<b>Consultation Response from KC Waste Strategy (Refuse &amp; Cleansing)</b>		
<b>PA no. &amp; address:</b> 2020/94203 Clough House, 236, Leeds Road, Birstall, Batley, WF17 0HW		
<b>Proposal:</b> Outline application for demolition of dwelling and associated outbuildings and the erection of 30 dwellings		
<b>Date Responded:</b> 05/01/2021	<b>Responding Officer:</b> Carol Oakden	<b>Responding Ref:</b> WPN-20-062

Boundary Treatments

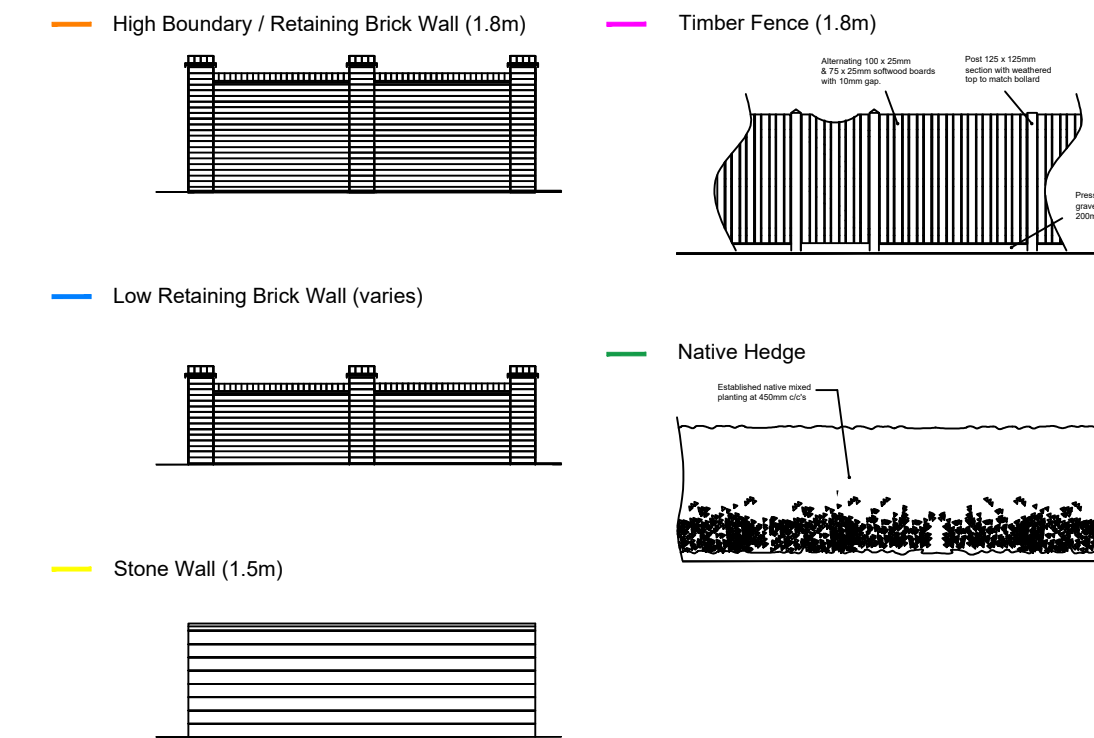
- Parked cars are a perpetual problem for RCV access and any likely places for this to occur should be accounted for on the swept path analysis.
- Gradients on the site may present difficulties with easy access routes between bin storage and presentation points. The boundary treatment sketch plan in the

submitted Design and Access Statement, suggests a 1.8m retaining wall to the south of plot 22, but this also shows gated access through this boundary, which is key to the rear bin storage for the plot. If the gradients of the site result in this arrangement being compromised, front storage for this plot will be required – this will need to be properly screened and located away from the doors/windows of the property. The same point applies to plots 2 and 8 off The Gables, and possibly plot 21. Bin storage for all affected plots will need careful consideration in the context of gradients if this introduces retaining walls, stepped access or slopes in excess of 1:12 for moving bins.
